# A303 Amesbury to Berwick Down

TR010025

## Additional Submission AS 10 – Shared Use Cycle Route Clarification Note

### Shared Use Cycle Route Clarification Note

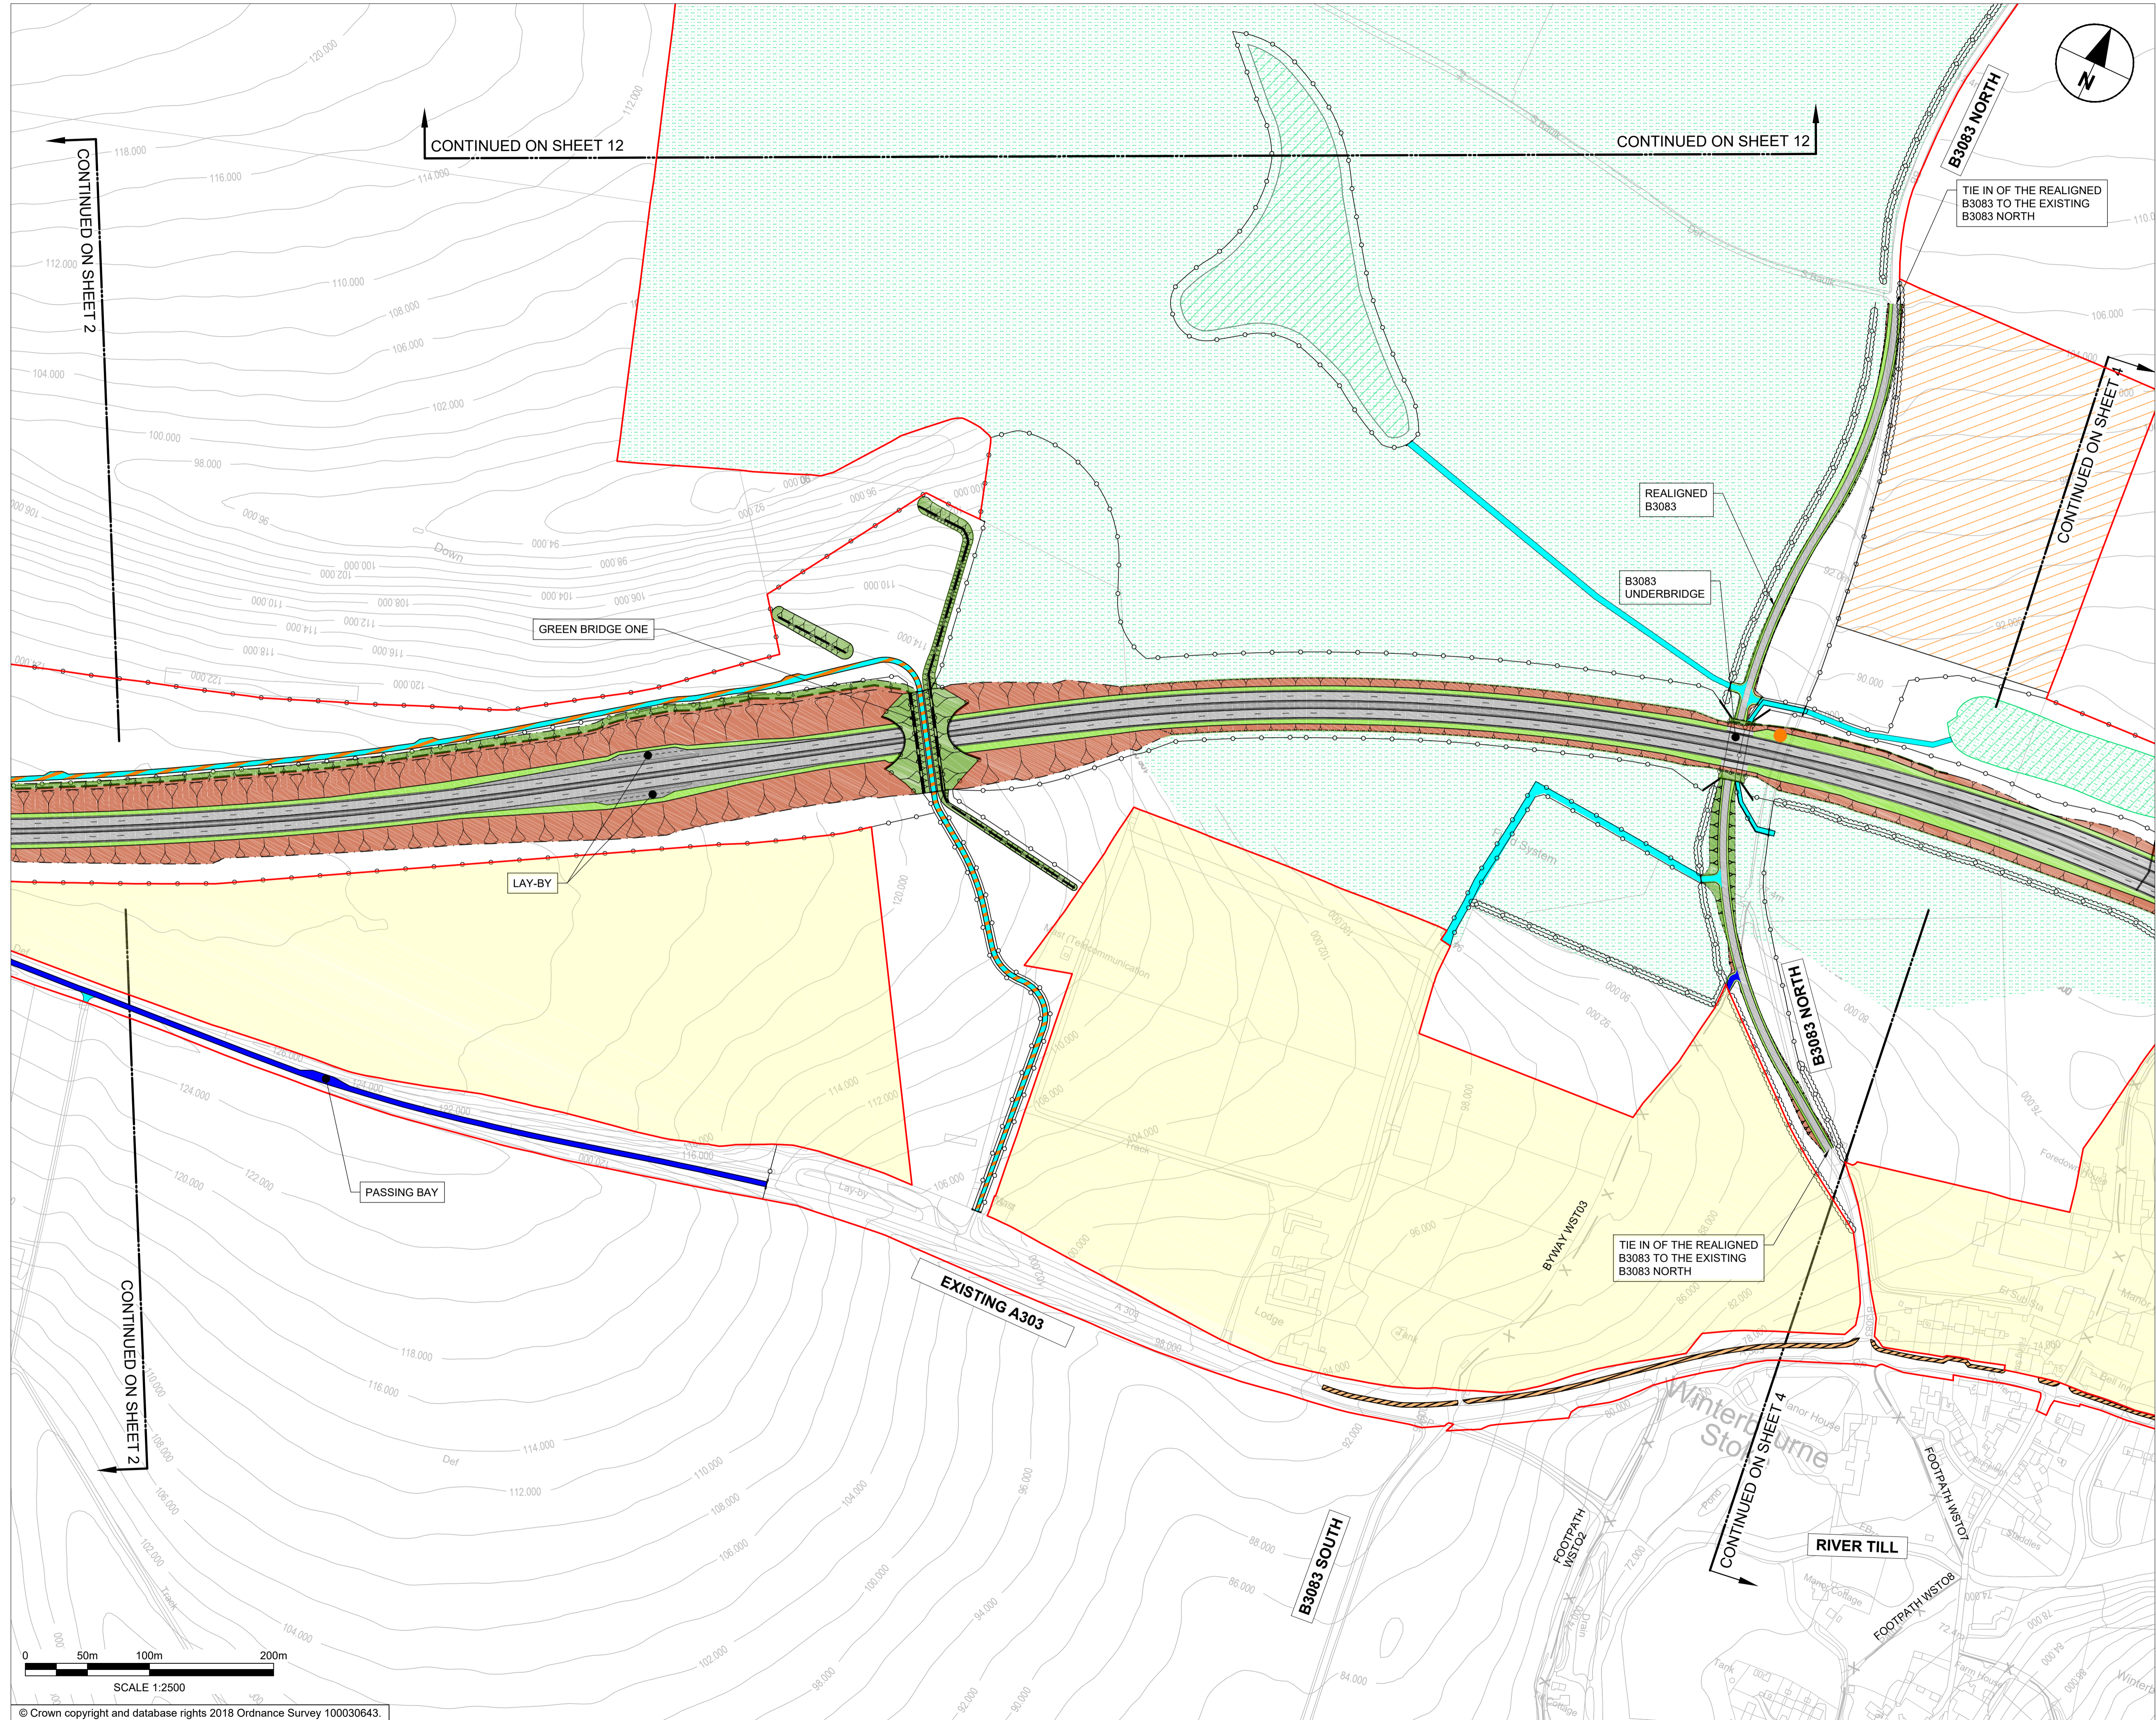
- 3.1.3 **Sheets 3 and 4** – the proposed brown route running along the northern verge and footway of the existing A303 between Scotland Lodge Farm and the western side of Winterbourne Stoke is intended for pedestrians and cyclists only and thus will be identified in the updated General Arrangement Drawings as a proposed shared use cycle track, shown in pastel orange with black diagonal lines overlaid. Equestrians would not be permitted on this shared use cycle track, but would be able to use the adjacent road through the village of Winterbourne Stoke, which, with the Scheme in place, will have much lower traffic flows following the removal of A303 through-traffic, and which will be subject to a 30mph speed limit.

- 3.1.4 Relevant abstracts of the existing General Arrangement Drawings Sheets 3 and 4 (marked ‘before’) and the proposed clarification (marked ‘after’) are shown in Figures 3-2 and 3-3 below.

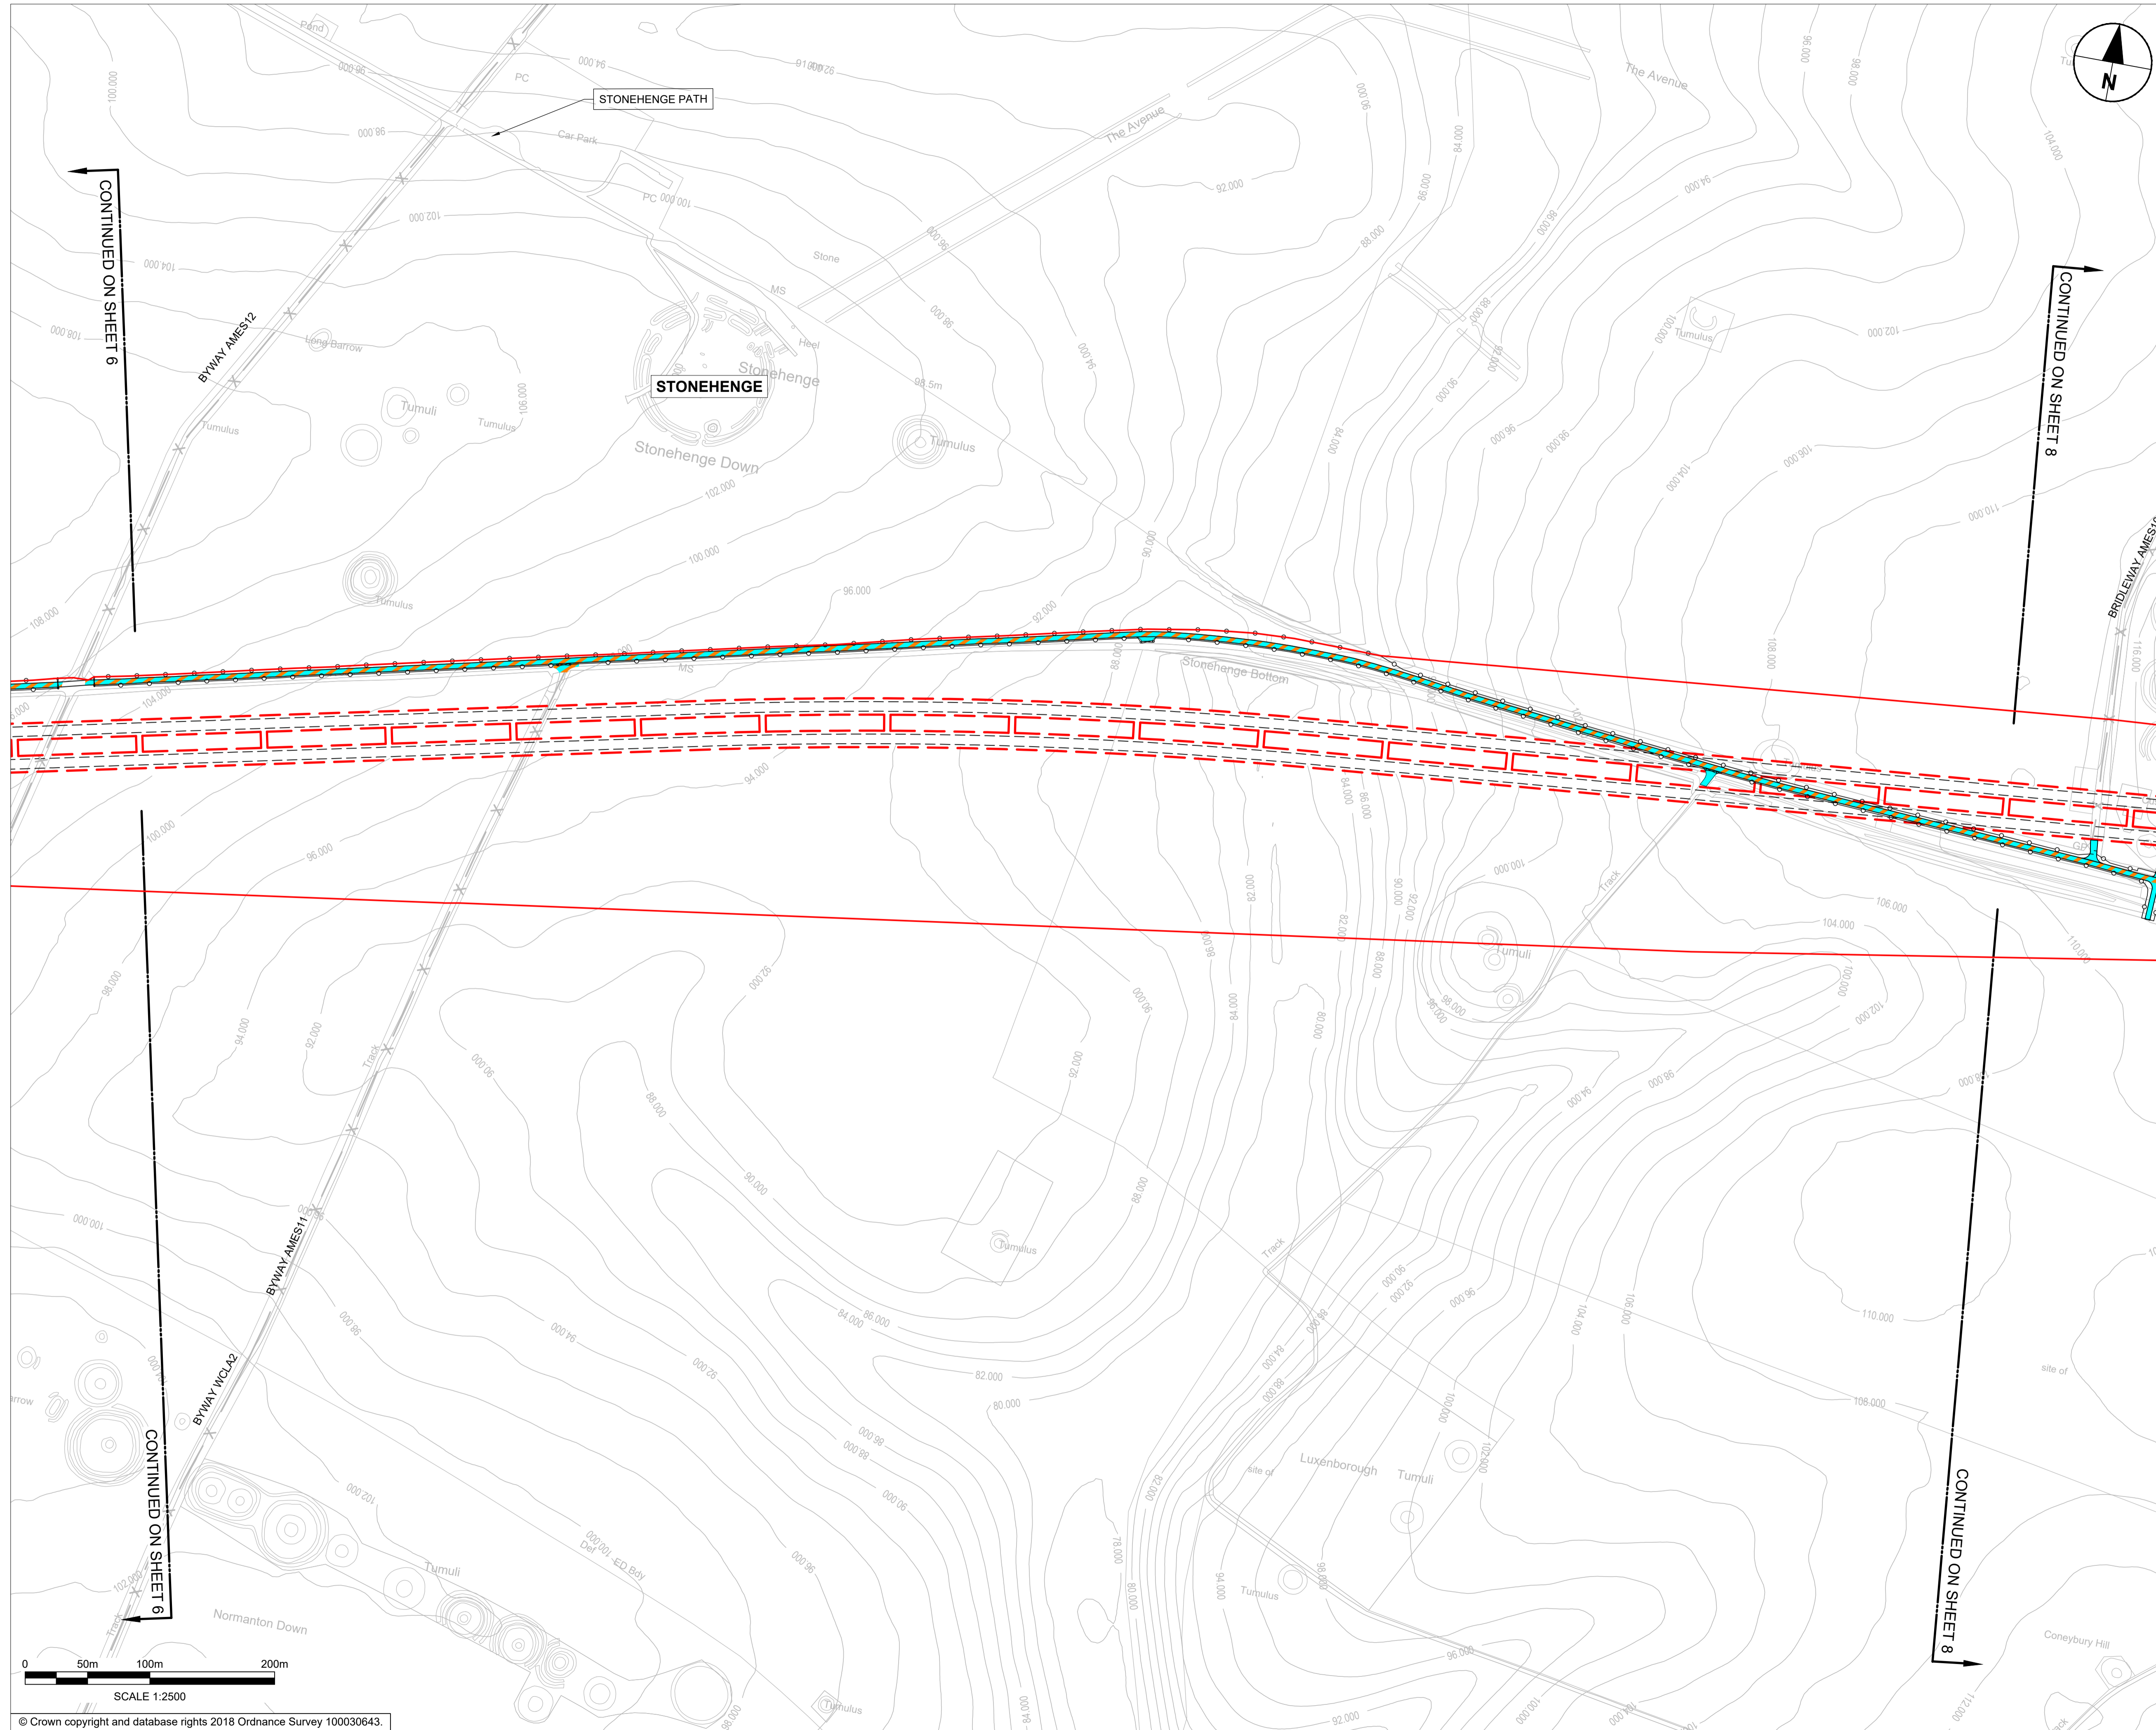
- 3.1.6 **Sheet 5** – the proposed brown route running along the northern side of the new link road (between the former A303 and the proposed Longbarrow southern roundabout, extending around the roundabout and leading into the proposed bridleway linking the new roundabout with the proposed restricted byway along the route of the existing A303) is intended for pedestrians, cyclists and equestrians only and thus will be identified as a “proposed cycleway” and shown in pastel orange on the updated General Arrangement Drawings.
- 3.1.7 Relevant abstracts of the existing General Arrangement Drawings Sheet 5 and the proposed clarification are shown in Figure 3-4 below.
